Our Case Number: ACP-323980-25

Re: Proposed Water Supply Project for the Eastern and Midlands Region
in the counties of Clare, Limerick, Tipperary, Offaly, Kildare, and Dublin.

Formal Objection to the Proposed Water Abstraction Project

This document serves as a formal objection to the proposed Water Supply Project for the Eastern and Midlands Region—SHANNON to DUBLIN WATER SUPPLY PROJECT (Ref. PA92.323980).

Drawing Title: Figure 4.62 RAW WATER INTAKE AND PUMPING STATION AT PARTEEN BASIN ACCESS ROAD

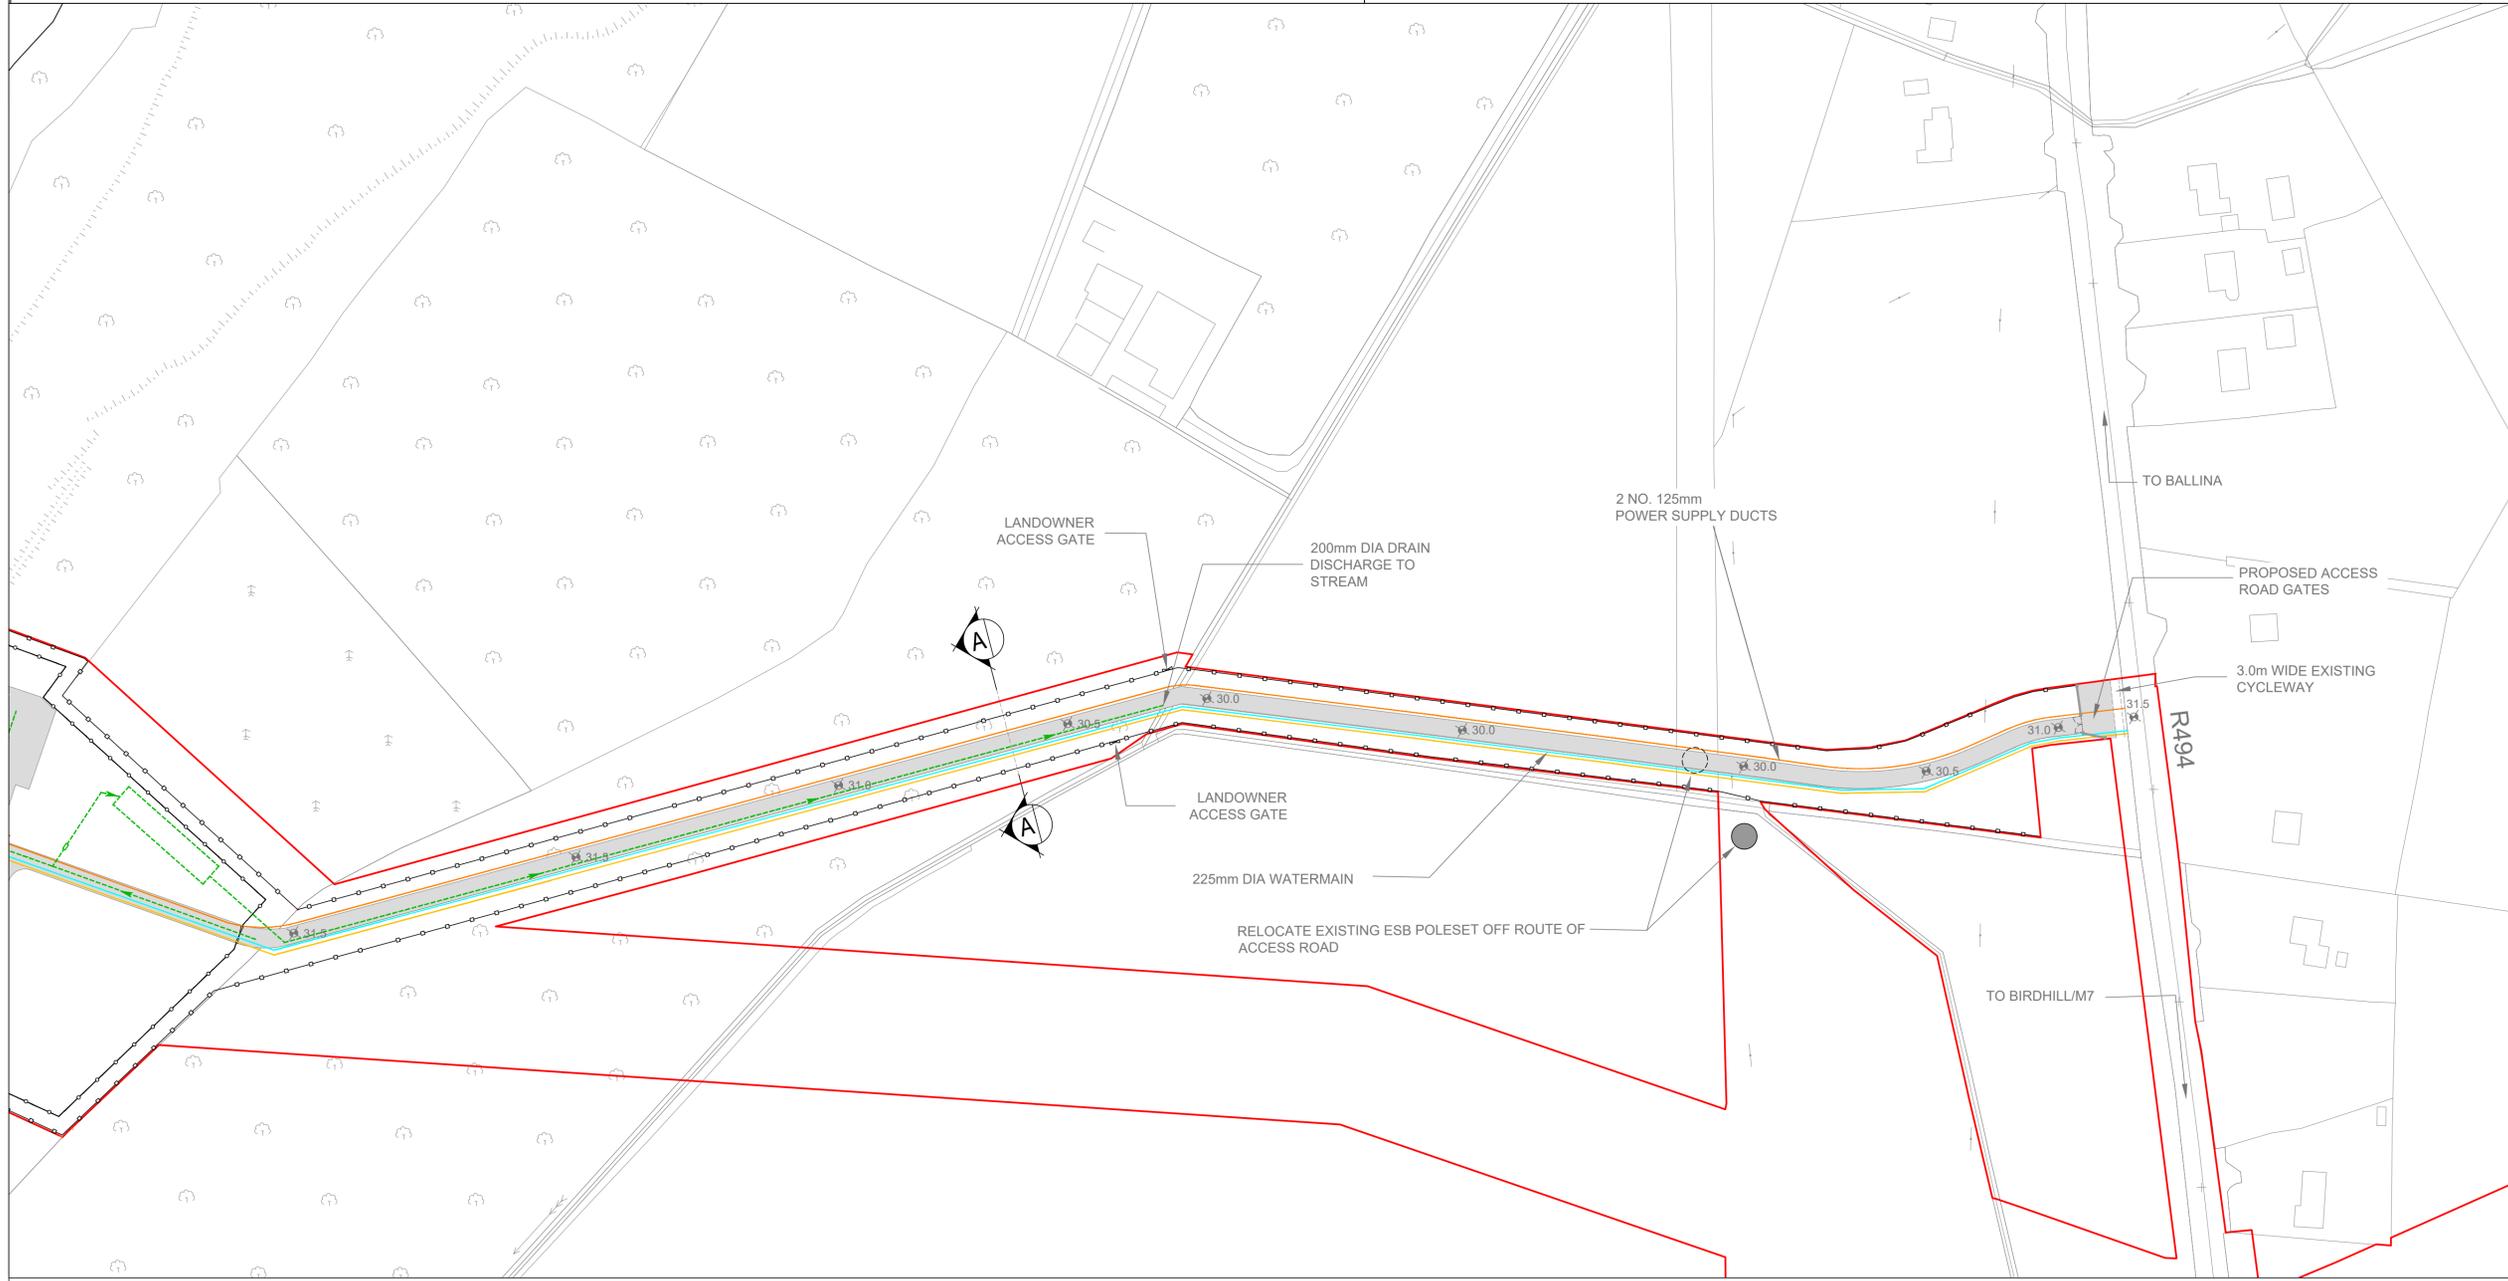
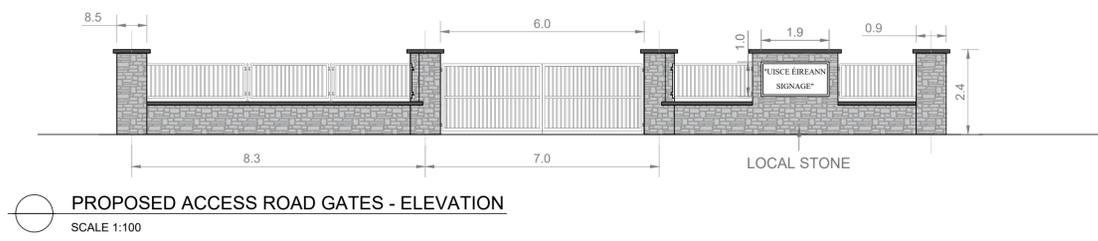
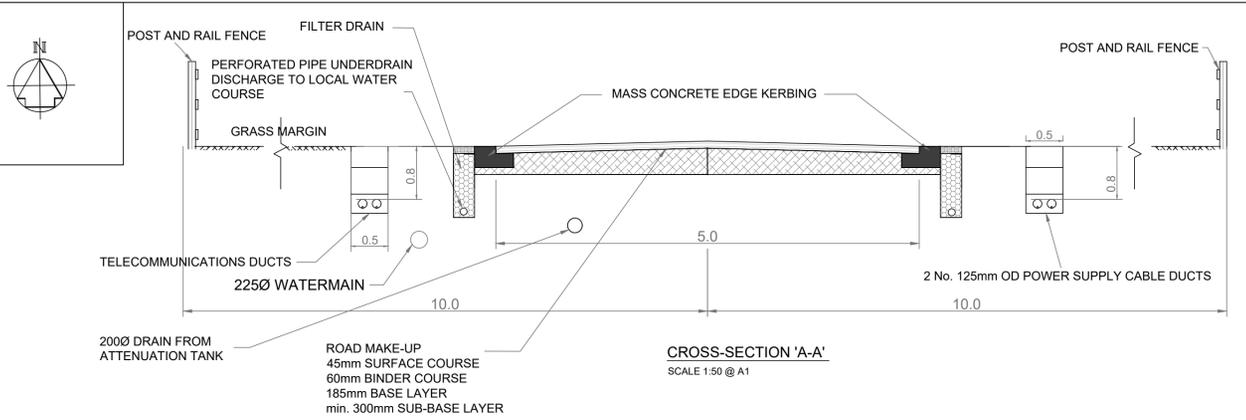
Consent under Article 6(3) of the Habitats Directive requires certainty that the development will not adversely affect the integrity of the Lower River Shannon SAC. The project presents a significant risk to spawning beds in the northwest lower lake, notably for bream, tench, roach, and pike, located merely 100 meters opposite the raw water intake pipes.

The alteration of natural flow patterns impacts retention necessary for migratory fish. The positioning of the intake is a particular concern, being at the final holding pool for migratory and juvenile fish in the Parteen basin—a critical area before migration into Lough Derg.

13. In the proposed restricted zone on the Shannon (100mx25m of buoys), we propose attaching a mesh from river bed to buoys as a secondary measure to prevent migration of fish toward artificially generated flows.

A 100-meter section of native woodland at the abstraction point will be directly impacted and removed, fragmenting shoreline ecology and worsening hydrological pressures within the Lower Shannon system. This woodland fulfills important ecological functions:
